Subject: RE: Planning Consultation on: WA/32/21/PL

Engineers Comments Regarding Surface Water Drainage

Application No: WA/32/21/PL

Site Address: Land at West Walberton Lane Walberton BN18 0QF

Opposite is the proposed drainage strategy

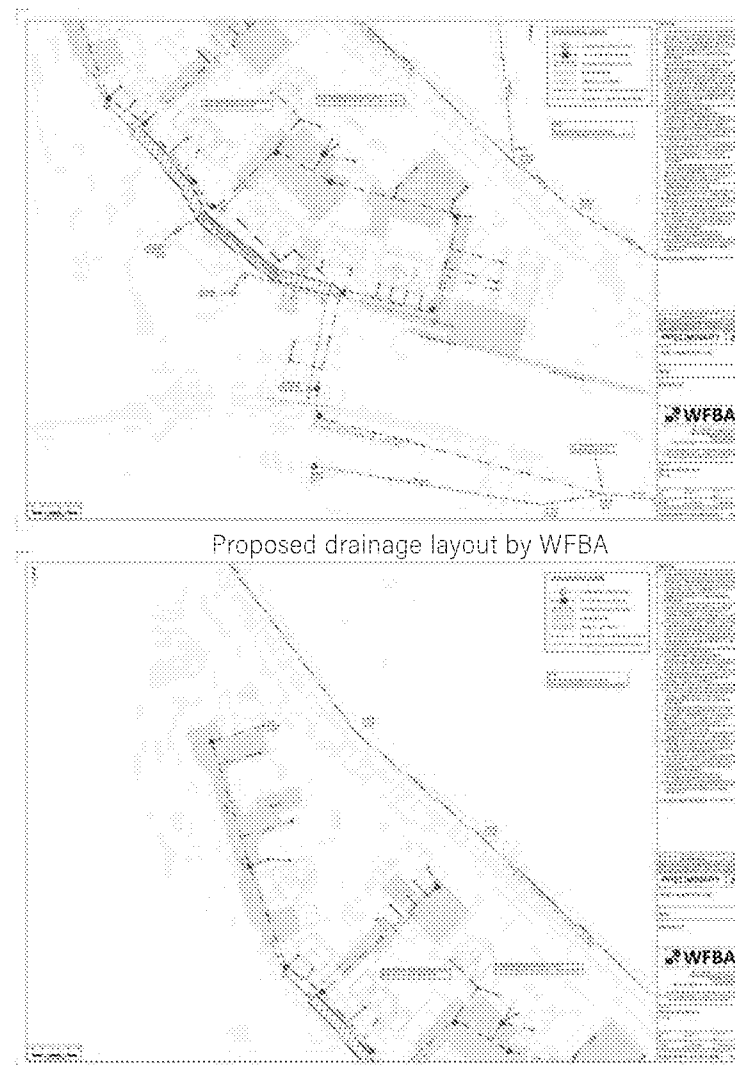
Despite infiltration being viable in the north-east and centre of the site, the applicant is proposing to collect and treat all surface water with permeable paving, attenuate it in culvert storage and SuDS pond and discharge it to the

neighbouring watercourse at a discharge rate of 4.4l/s. This is inappropriate and does not follow the drainage hierarchy (LLFA SuDS Policy 1) or mimic the natural drainage catchments of the site (LLFA SuDS Policy 3).

As infiltration has been found to be viable in parts of the site we expect the surface water drainage strategy to be revised. The new strategy should maximise infiltration where possible and attenuate surface water from the remaining areas before discharging to the watercourse at an agreed rate, this is commonly referred to as a hybrid strategy. No calculations have been provided to justify the previously proposed discharge rate which seems high for a greenfield site. We would expect the rate to be calculated on the basis of the positively drained area only, this will likely decrease the discharge rate.

The watercourses on the west and south-east boundary are classified as Main River. As such, if the applicant intends on discharging water to either of these watercourses they will need to apply for an Activity Permit from the Environment Agency. If they propose (as drawn) to discharge surface water to the ordinary watercourse on the south boundary, they would need Ordinary Watercourse Land Drainage Consent in order to do this, they would also require consent in order to construct the proposed culvert at the site entrance.

At this stage no calculations have been provided to support the sizing of any of the surface water drainage components. Therefore we do not know if more area take up is required for surface water drainage. At this stage it is unclear if it is possible to design a SuDS scheme on this site which is compliant with policy requirements and adequately considers all sources of flood risk.

The Drainage Strategy Statement indicates that the applicant intends to install a pond on the site. This is intended to serve dual purposes, as a surface water storage feature (with variable water levels), and to provide biodiversity benefits on site. The applicant is proposing to *“excavate within the area of the proposed pond to reduce levels to meet the current groundwater level. This will increase the potential storage capacity and communicate directly with the groundwater to establish the pond.”* Peak groundwater level at this location is at ground level (WS4). Therefore minimal excavation will be necessary to provide connectivity to groundwater, and certainly no additional (permanent) storage will be provided by doing so.

The proposed pond is located within Flood Zone 3 in an area at risk of both fluvial (river) and pluvial (surface water) flooding. This currently dry area, provides storage for flood water. If the banks of the pond are raised up, preventing flood water from entering then this will displace flood water and increase offsite flood risk. If they do not raise up the banks then the pond cannot be relied upon for surface water drainage, and there may still be floodwater displaced by standing water levels or the surface water from the site which is connected to it. No calculations or modelling have been provided to prove that flood risk will not be increased on site or elsewhere by the inclusion of this pond in a flood storage area (NPPF para 167, and LLFA SuDS Policy 4).

There appear to be trees in very close proximity to attenuation features. Please ensure all existing and proposed trees are shown on drainage layouts. Attenuation features must not be located within the tree root (present and future) zones. The surface water drainage design should be considered in conjunction with arboricultural. Not considering the two together can lead to complications, delays and unnecessary compromises as a result of an inappropriate layout.
